Agenda for Quik Trip #7000 Scoping Meeting

12th and I-40

April 17, 2024

SHEET NUMBER:
FIG 1.0

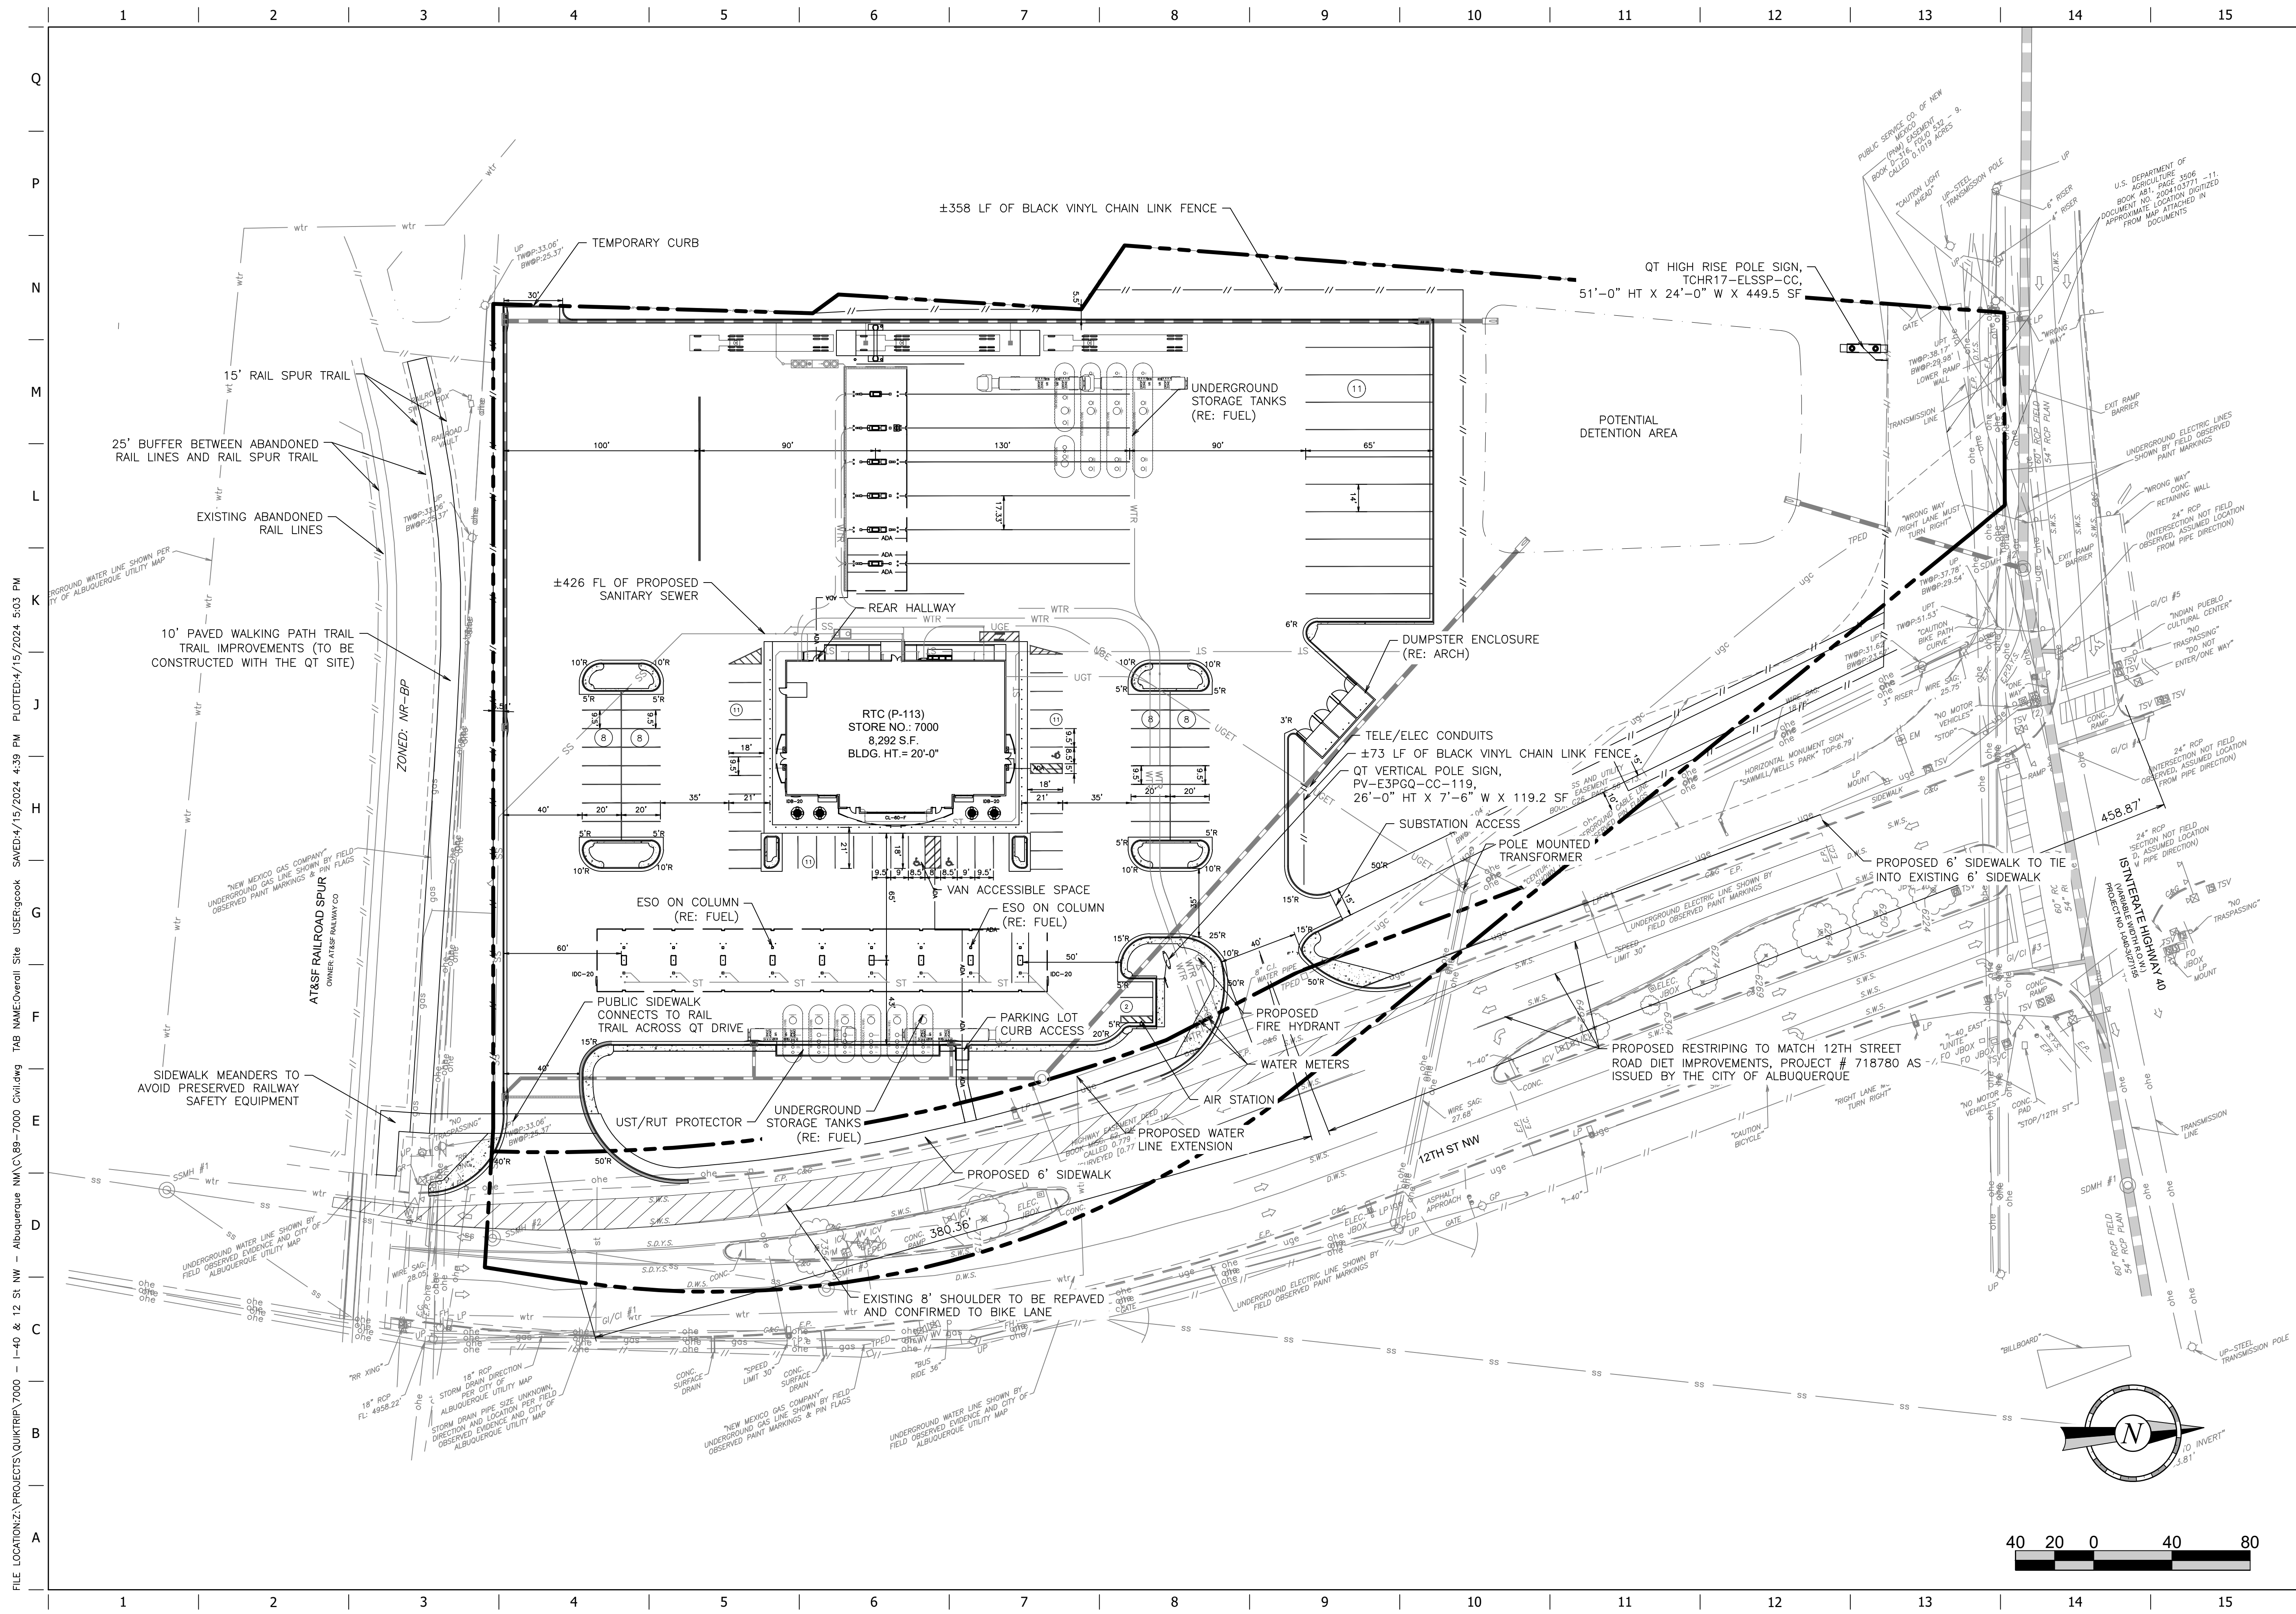
1. Introductions
2. Review of Site Plan
 - a. Site Plan & Land Uses
 - b. Access Review
 - c. **Review driveways for SAMM**
3. Discussion of Scope for TIS
 - a. Study Intersections

- i. **12th & I-40 Ramps**
 - ii. **12th St and Lowes Driveway**
 - iii. **6th & I-40 Ramps**
 - iv. **Median break for US Services Administration**
 - v. **Median break for 1600 12th St**

- vi. **Site Driveways**
 - b. Data Collection
 - i. Existing Study Intersections
 - c. Trip Generation, Pass By, & Internal Capture
 - i. Trip Generation Manual (11th Edition) Land Use

- iii. Opening Year Buildout (Full Build)
 - 1. Two scenarios required if northern driveway is full access.
 - iv. Opening Year Buildout Optimized (if required)

- 2. Highlight bike & ped crashes / trends
 - vi. Access Justification
- 4. Agency Input (Comments & Issues)
 - a. Coordinate with road diet project.
- 5. Meeting Notes (distributed by Lee Engineering)
